REP3-052 page 153, item LV1.9.46

Drawing title: **AB-AP5
Proposed Visibility Splay
Concept Design
Sheet 1 of 1**

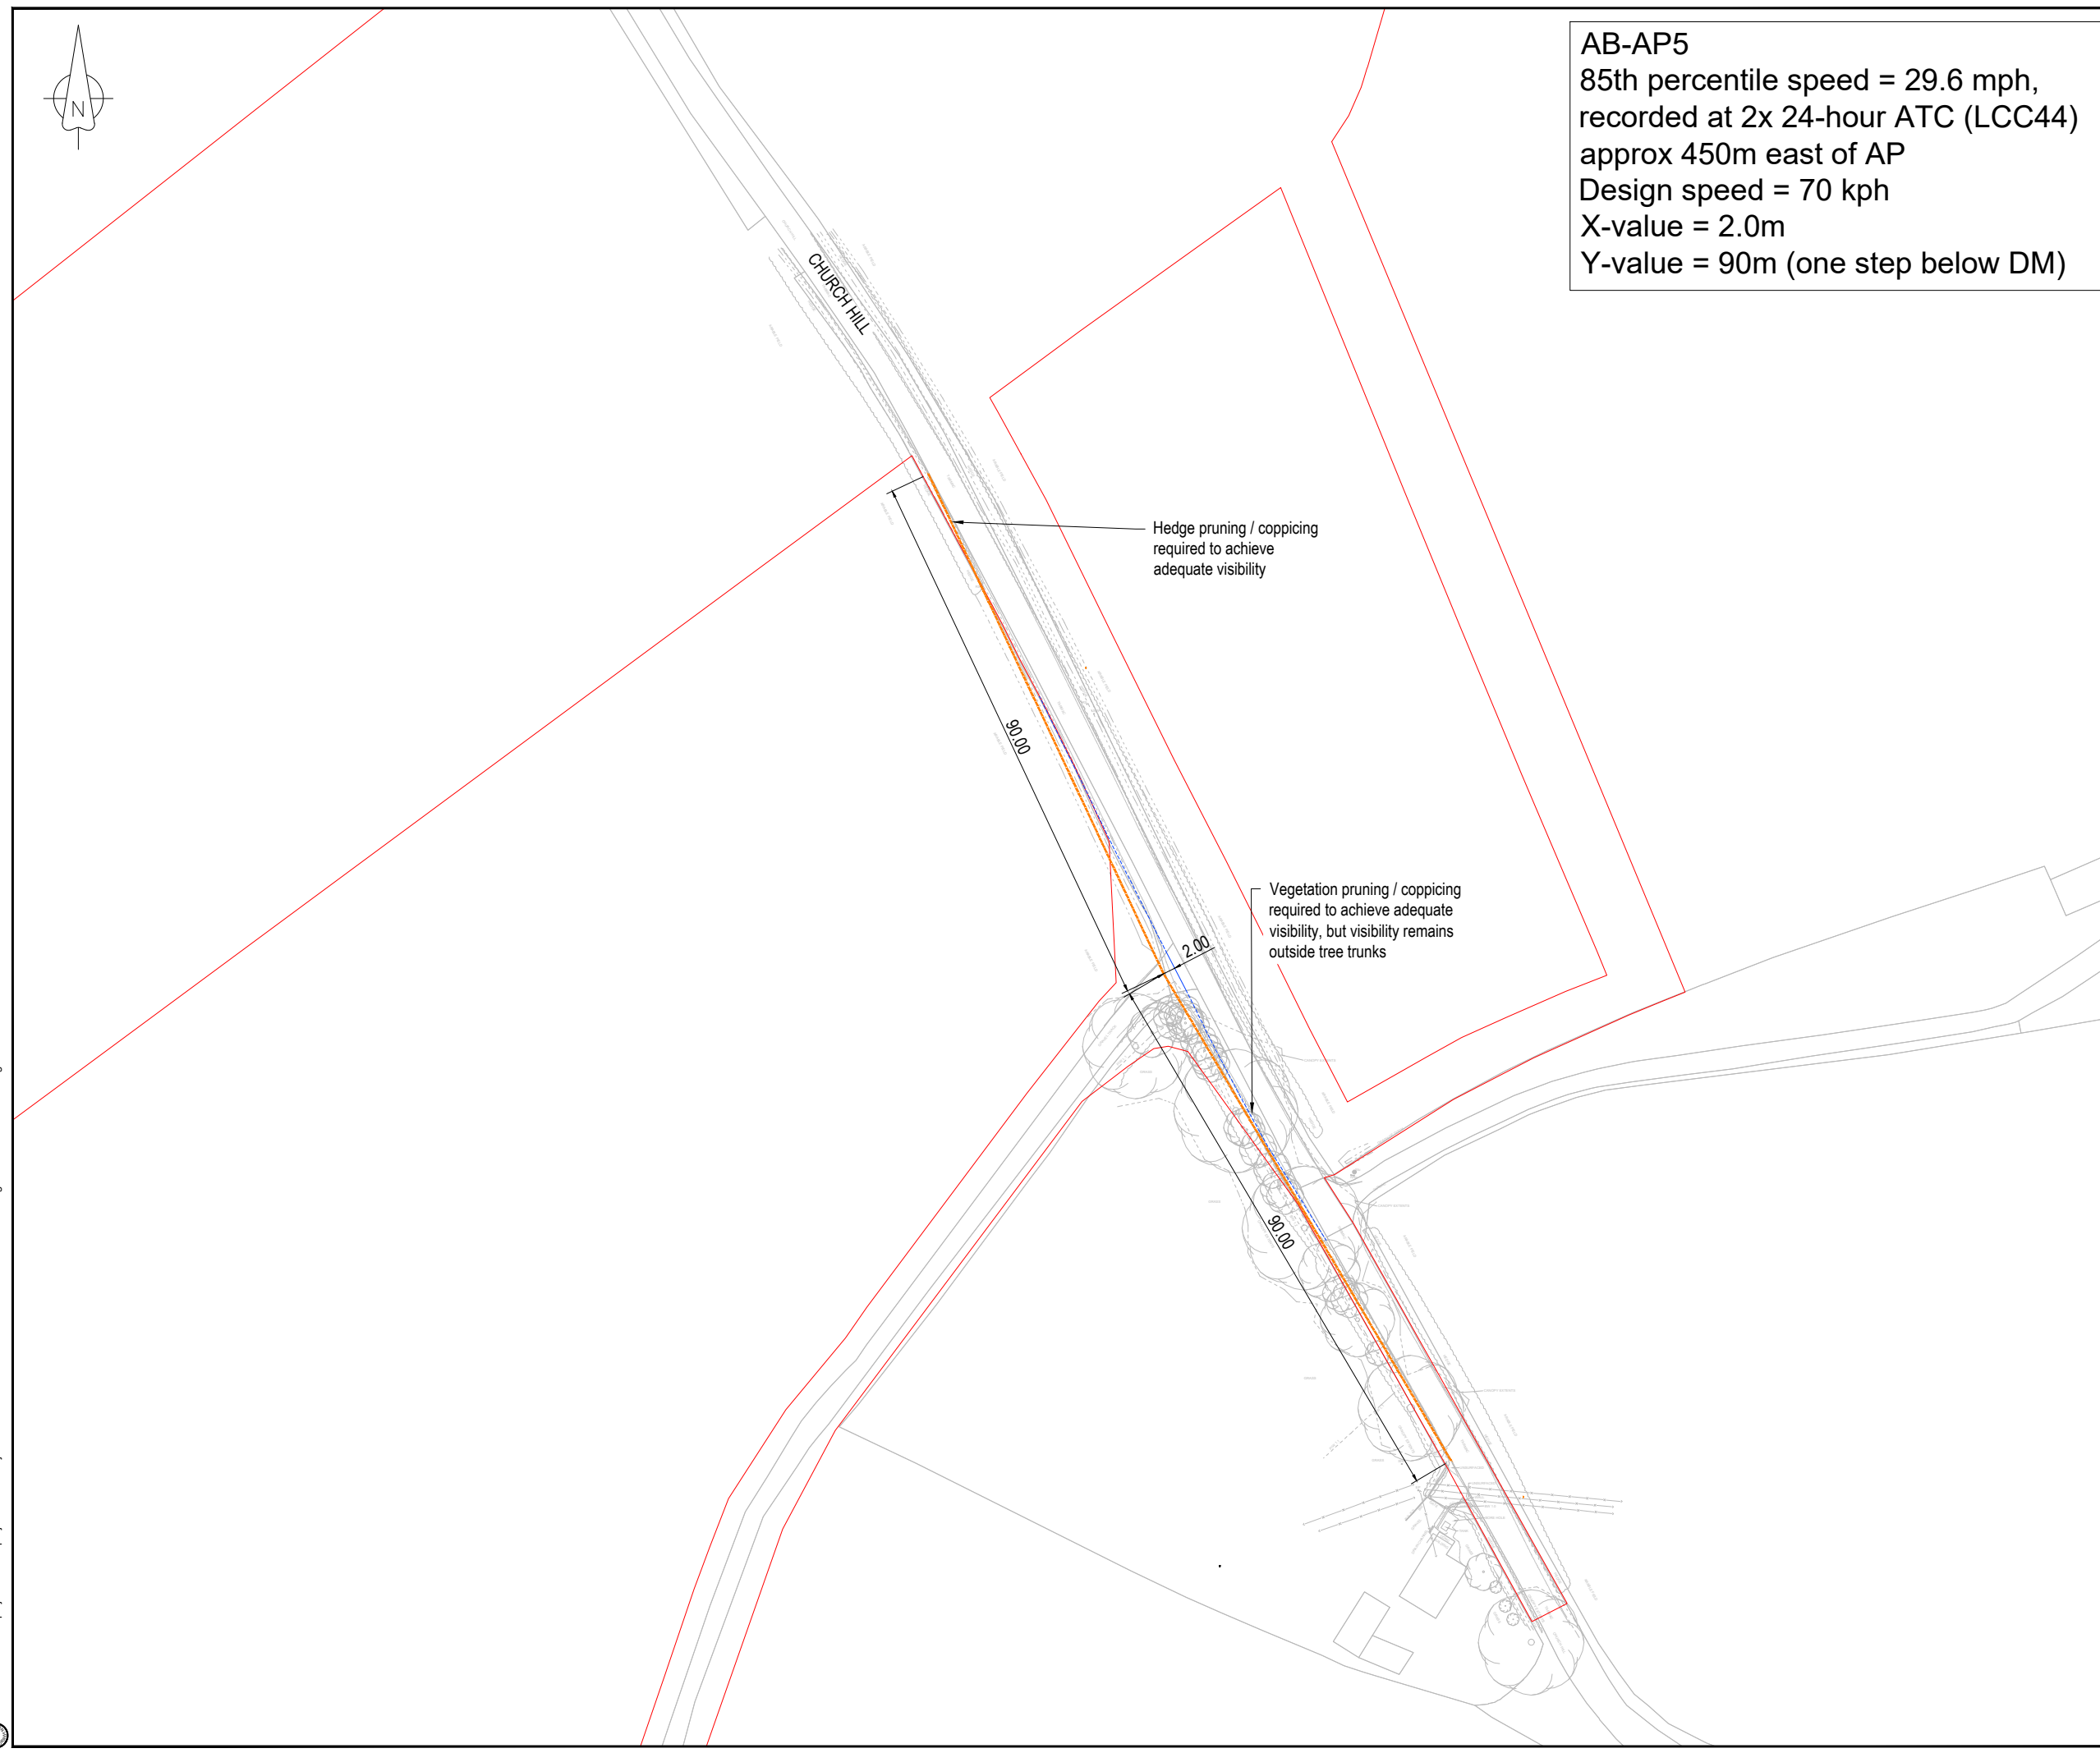
The Applicant's response cites worst case visibility splay requirements (hence dictating hedge and tree removal) grossly at odds with Suffolk Highways standard conditions as published by them and further clarified by them at the Issue 3 hearings. Additionally, these greater SCC figures are based on the assumption that a 30mph scheme could be implemented at this location. It is therefore likely that the environmental damage will now be significantly in excess of that previously discussed, and correspondingly unlikely that the (so far only informally) proposed mitigation of requiring only minimal vegetation trimming can be achieved.

The ExA raised a specific query regarding this location but the Applicant has offered a generic response based on a statistical analysis across the whole project. Furthermore this analysis covers only "vegetation" based on short term regrowth of hedgerows. At this site, mature oak trees will be felled, which would fall outside this scope and so have not been covered in the assessment. Note that none of the affected oak trees bordering the highway appear as discrete trees in the Arboricultural Impact Assessment although lesser ones along the northern track boundary do. This has rendered the trees "invisible".

The Applicant has not answered the Examining Authority's second question at all: "Explain why you were not able to propose a less damaging option". A less damaging option does exist, as proposed by the property owner, so the absence of a response here is unsatisfactory.
